Harbour Energy Proposed Protective Provisions

Shown as mark-up to the Harbour Energy Without Prejudice Protective Provisions as Submitted by the Applicant at DL5

Development Consent Order: Schedule 3 Spirit and Harbour Protective Provisions Plan

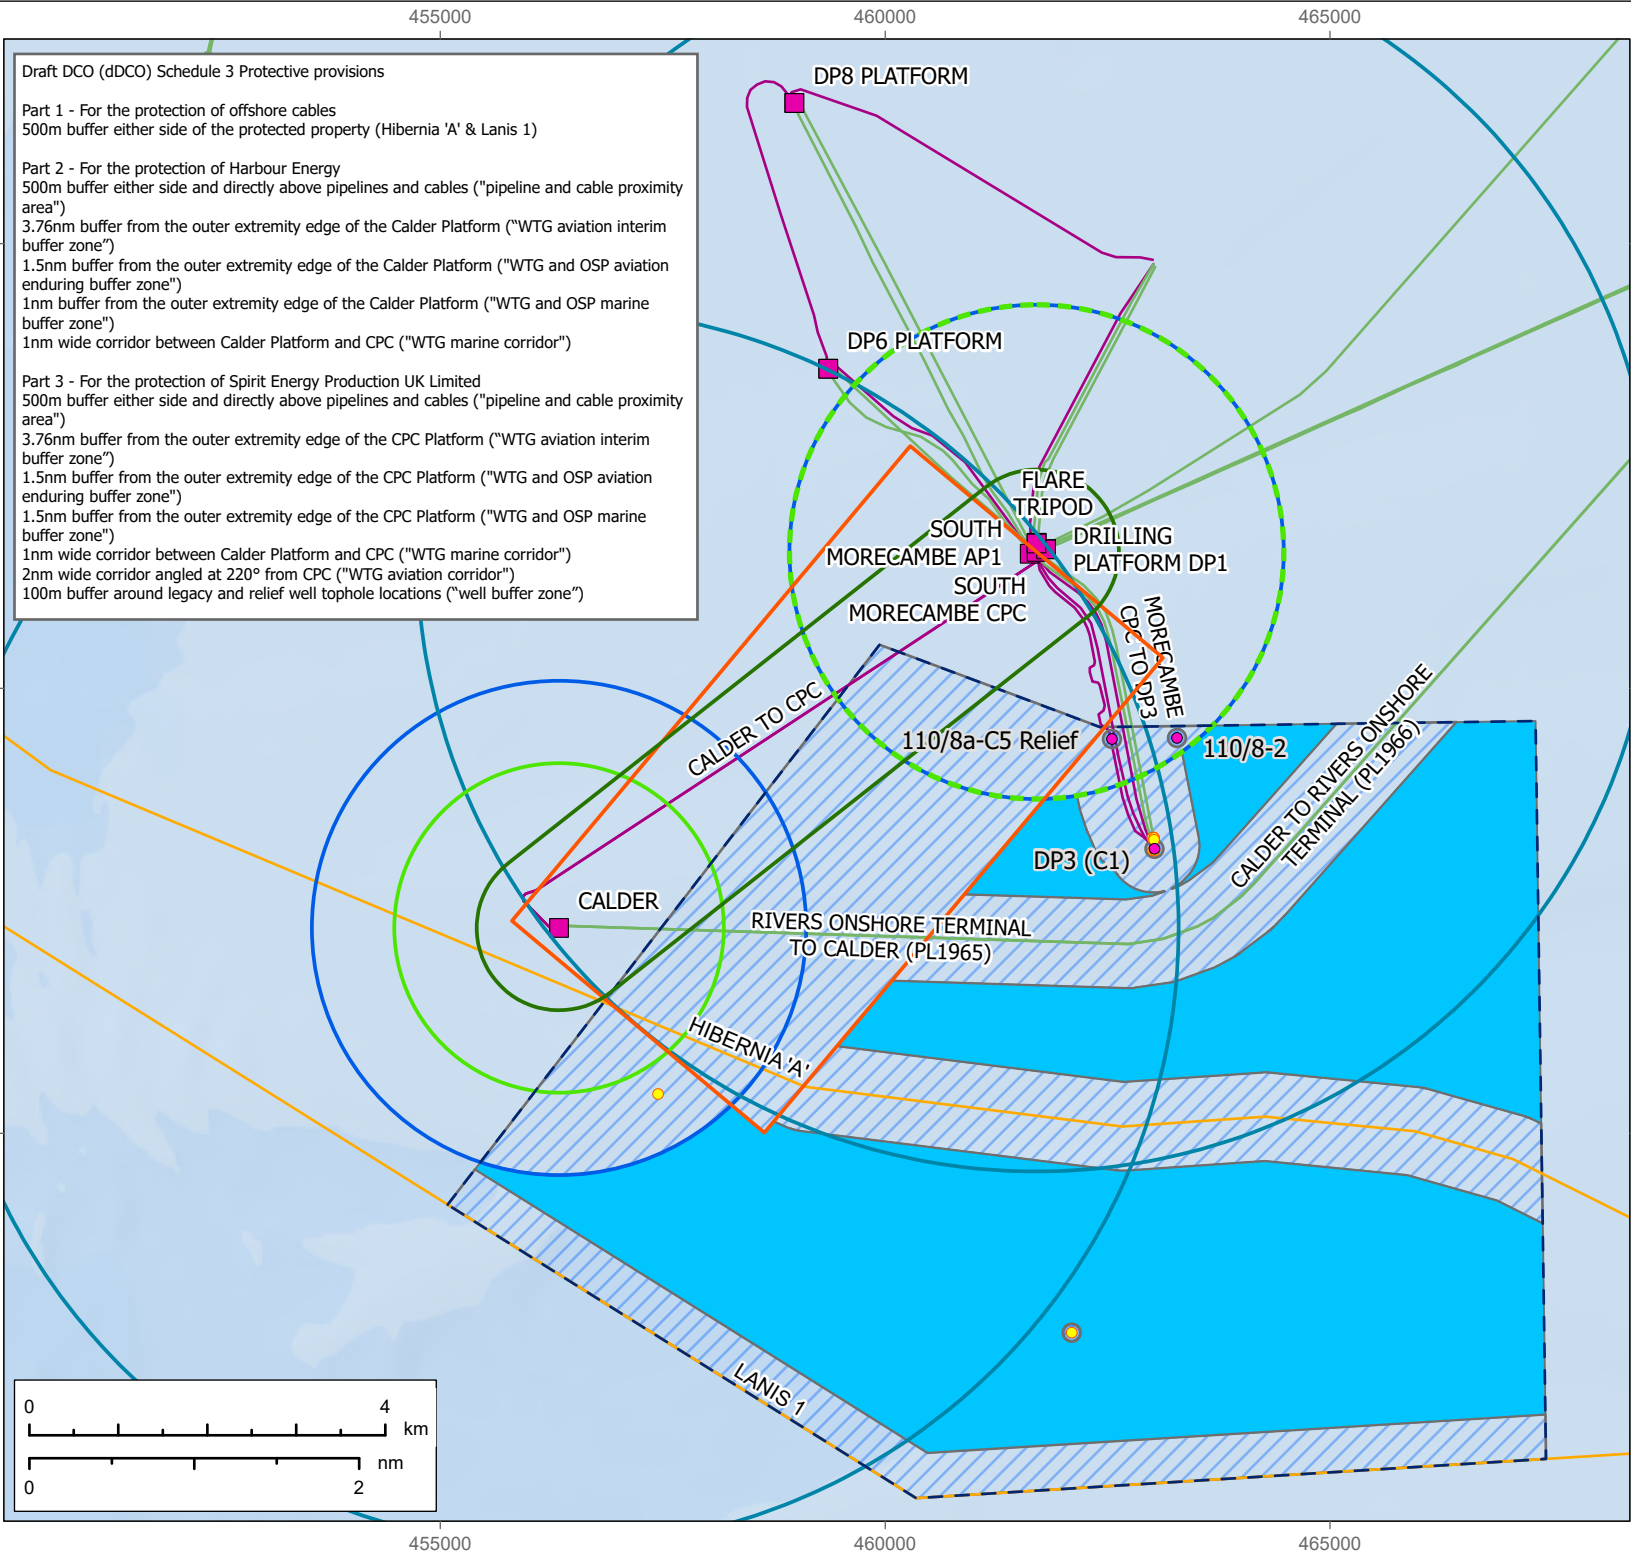
In the interests of co-existence, and as a development from earlier submissions, Harbour Energy is willing to accept that, with suitable compensation provisions, post-COP decommissioning work could be undertaken with rotor tips no nearer than 1.9nm. As clearly set out in Harbour Energy's Written Representation (REP1-102), the AW169 aircraft used in the East Irish Sea require an obstacle-free distance of 1.9nm upwind of a helideck in order to execute a take-off or a missed approach should one engine become inoperable. The Applicant has challenged this distance but Harbour Energy re-iterates that this distance has been confirmed by our aviation specialists by reference to the performance graphs in the aircraft operating manual and also by the helicopter operator operating these aircraft on behalf of Spirit Energy, including those to the Calder Platform. In support of this change from Harbour Energy's DL5 submission (in which 3.76nm was required for both pre-COP and post-COP operations), the drafting of these protective provisions places significant emphasis on the compensation provisions and

“WTG and OSP aviation post-COP buffer zone” means a circular area of one point nine nautical miles (1.9 nm) of clear airspace measured from the nearest outer extremity edge of the Calder Platform to any tip from any wind turbine generator located within the order limits and extending vertically from mean sea level, shown edged blue and annotated and shown as the WTG and OSP aviation post-COP buffer zone on the Spirit and Harbour Protective Provisions Plan;

(2) On and from the decommissioning date for Calder, no wind turbine generator or offshore substation platform shall be erected in the WTG and OSP aviation post-COP buffer zone unless otherwise agreed in writing between the owner and the undertaker.
